## The Sydney Boys High School Parents and Citizens Association

### Submission to Environmental Impact Statement (EIS) – CBD & South East Light Rail (CSELR) from the Sydney Boys High School P&C Association

### ***Submission to the 2013 Environment Impact Statement for the proposed CBD and South East Light Rail (CSELR) – Moore Park Precinct.***

Figure 7-12: Moore Park Precinct Access Plan

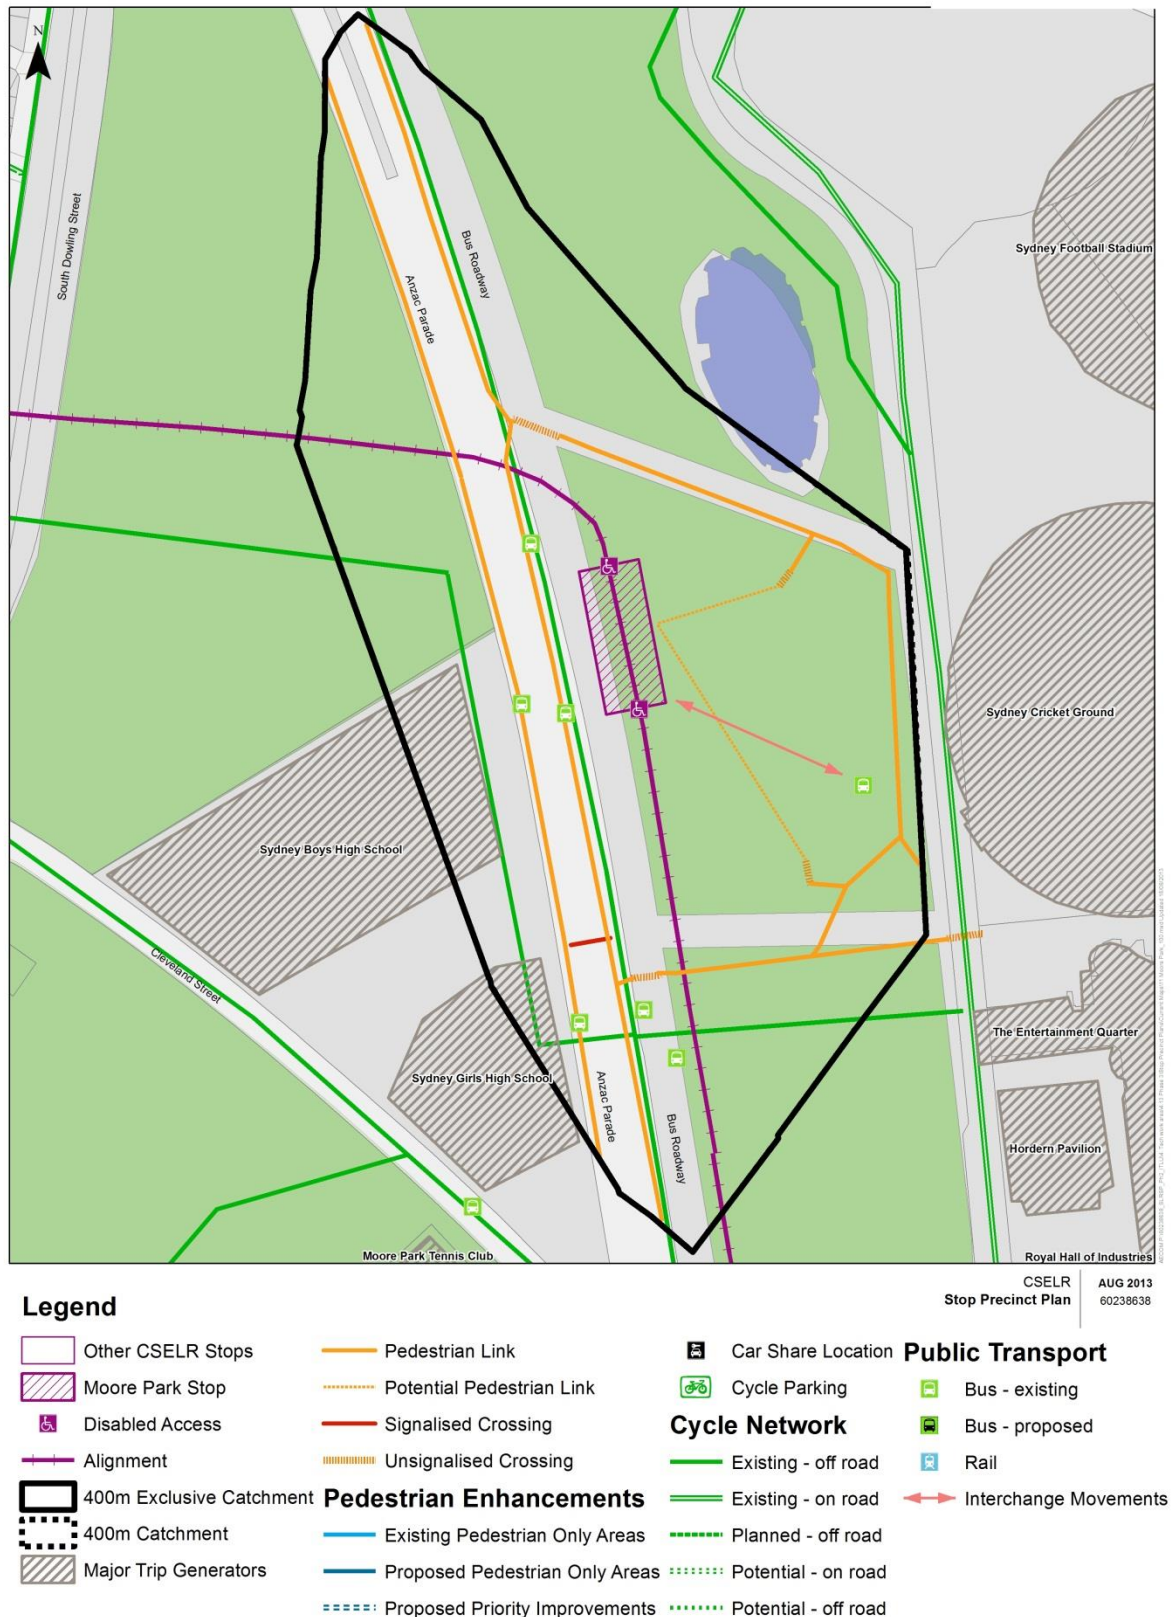
This view of the EIS would imply that road safety issues crossing Anzac Parade have not changed with the development of the Light Rail station in Moore Park. This is incorrect. Presently most students at SBHS and the adjacent Sydney Girls High School do not cross Anzac Parade during the 3-3.30 PM rush hour when they leave school to return home via Central railway station. This is because there is a dedicated bus pick up at the two schools along the Anzac Pde footpath that is adjacent to the schools.

The P&C notes that as a direct result of the CSELR over 2,000 students will have to cross Anzac Pde and the parallel bus lane between 3-3.30 PM each school day (or 10,000 students per school week). This will represent a significant increase in risk for an accident.

*"The design of the Moore Park stop and associated pedestrian pathways would not preclude the future development of a potential pedestrian bridge over Anzac Pde (which is outside the scope of this EIS)".*

This statement would imply that a pedestrian bridge across Anzac Pde might be necessary but then somehow excludes it as part of the construction of the CSELR. Why would the construction of a pedestrian overpass across Anzac Pde NOT be part of the EIS when, without the proposed Light Rail, it would not be necessary to consider an overpass. Unless evidence is provided otherwise, this overpass is essential i.e. it must be included as part of the overall Light Rail construction.

- a. **Crossing Anzac Pde in the afternoons during school days:** As a direct result of the CSELR an additional 2,000 students per day will need to cross Anzac Pde to reach the Moore Park Stop. This will represent a surge of students over a short time period (3.00 -3.30 PM) which is also a peak time for traffic. Put in another way, 10,000 additional new crossings over Anzac Pde will be needed by students during each school week. It is difficult to follow how the EIS proposes that no changes to the current arrangement for crossing Anzac Pde will be needed to ensure safety in crossing Anzac Pde under these circumstances. As far as the P&C can assess, no evidence was given for this position in the EIS. As a very minimum we would have expected to see a statement by a traffic engineer confirming that the CSELR would not pose any additional risks for the crossing of Anzac Pde.

- b. We note that the Moore Park Stop is not being placed below ground so it will be visible to students who are crossing Anzac Pde. Inevitably some students will see a tram approaching and not wait until pedestrian crossing lights turn in their favour. This will be a particular worry for students who live a distance from the CBD and must make timely connections with trains or ferries to reach their homes. While the students might be “at fault” should an accident occur, there is also a duty of care by responsible parties including government since this type of accident is preventable.

- i. Evidence must be provided for significant decisions related to safety of children crossing Anzac Pde (and to some extent Cleveland St). Without conclusive evidence that the CSELR does not pose any additional risk for the >10,000 additional crossing required each school week, the only solution that is legally defensible and addresses duty of care considerations must be a pedestrian over-pass to cross Anzac Pde complemented by measures that would

prevent the crossing of that road by pedestrians e.g. closing pedestrian crossing / traffic lights on Anzac Pde located between SBHS and SGHS, and securing footpaths on both sides with fencing. In addition, we would expect that the current Cleveland St crossing is made more secure by fencing along the length of the footpath on both sides of this busy road which will only get busier with traffic related to the adjacent construction site.
